CITY OF ALBUQUERQUE

August 14, 2019

**RE: Office/Warehouse
4000 Ellison St. NE
Conceptual Grading and Drainage Plan
Engineer's Stamp Date: 07/11/19
Hydrology File: D17D074**

Based upon the information provided in your submittal received 07/24/2019, the Conceptual Grading and Drainage Plan **is not** approved for action by the DRB on Site Plan for Building Permit. The following comments need to be addressed for approval of the above referenced project:

GRADING AND DRAINAGE PLAN

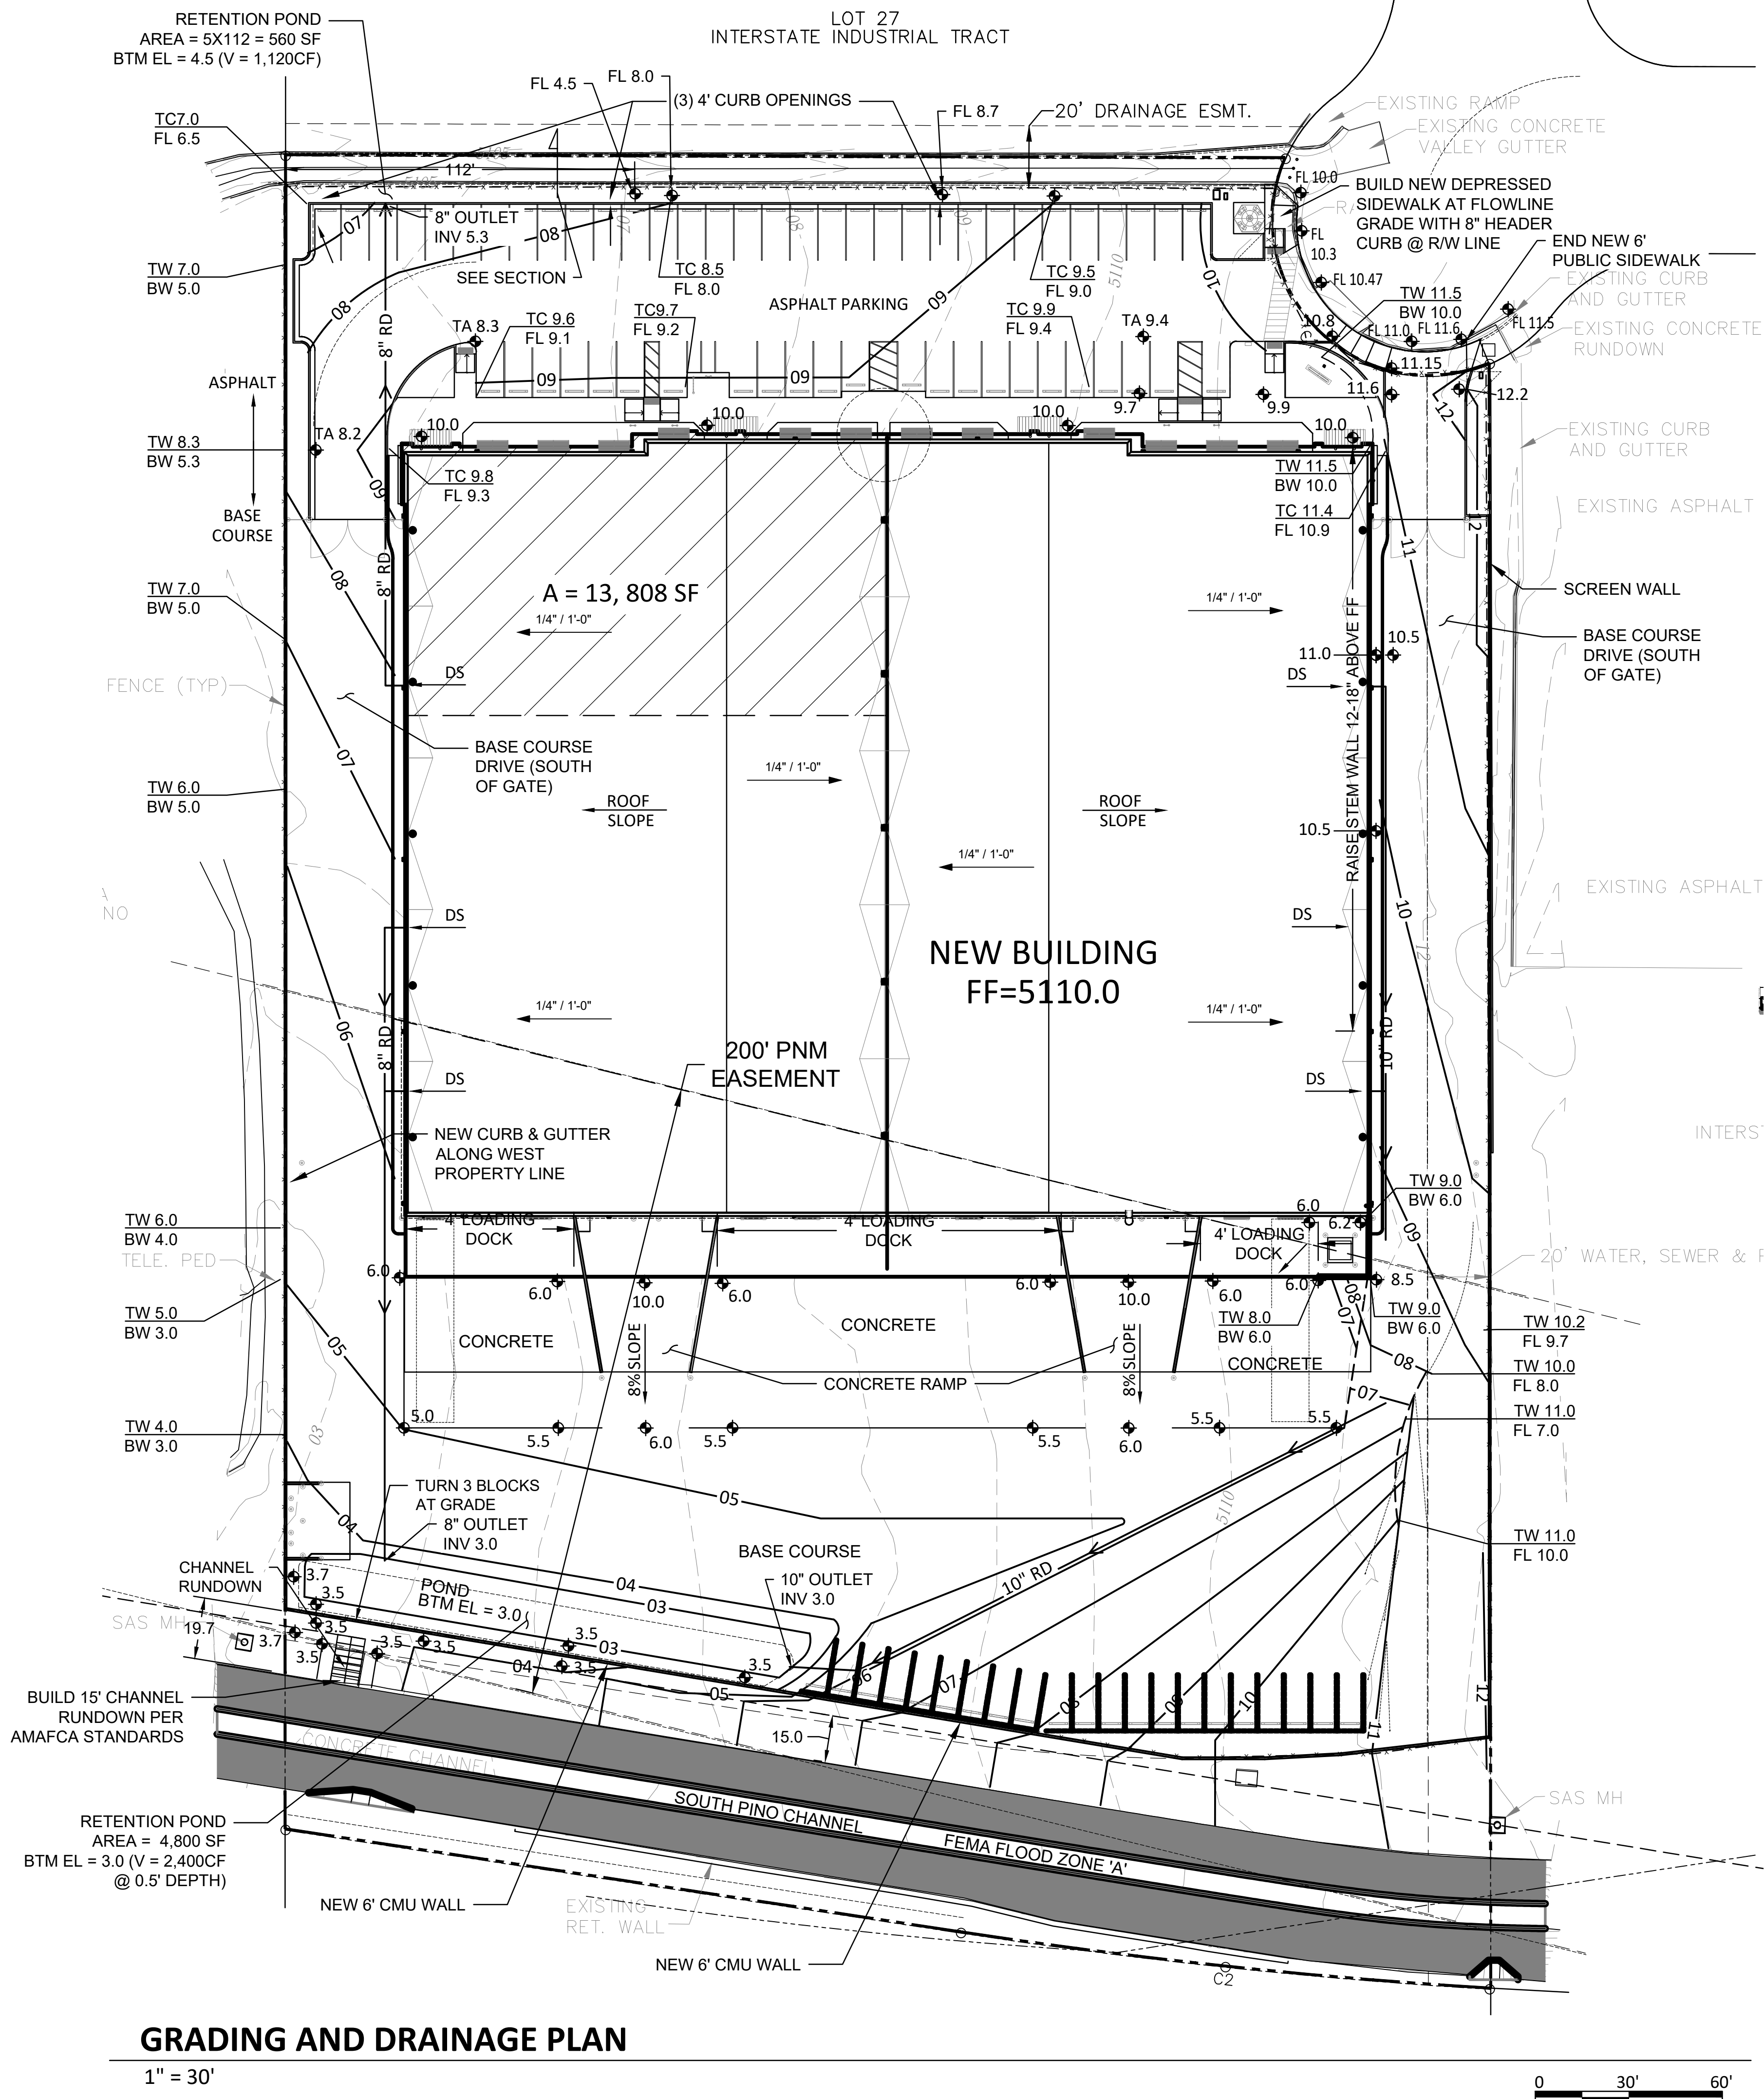
1. Please provide the FIRM Map.

2. Please show the floodplain Zone "A" along the South Pino Channel per the FIRM Map.

3. Please label the streets and South Pino Channel.

4. Please add a label "Not For Construction" on the Conceptual Grading Plan.

- The Site Plan should say 'Flood Zone' not 'Flood One'.
- The G&D and landscaping plans show parking along the east property line south of the existing chainlink fence and into the drainage easement, but the site plan does not. Is the existing fencing to remain or will it be removed?

- Any work within a drainage easement needs to be coordinated and permitted with AMAFCA.
- The site grading impacts the AMAFCA access road along the top of the concrete channel. Vehicular access needs to be maintained.

- The water quality pond should overflow towards the concrete channel and construct a Channel Rundown per the AMAFCA STD Details.
- Add a curb along the west property line and direct all runoff south & through the water quality pond.

- AMAFCA does not typically allow private storm water quality ponds within drainage easements. Since there is available space, move the pond to the north & outside of the existing drainage easement.
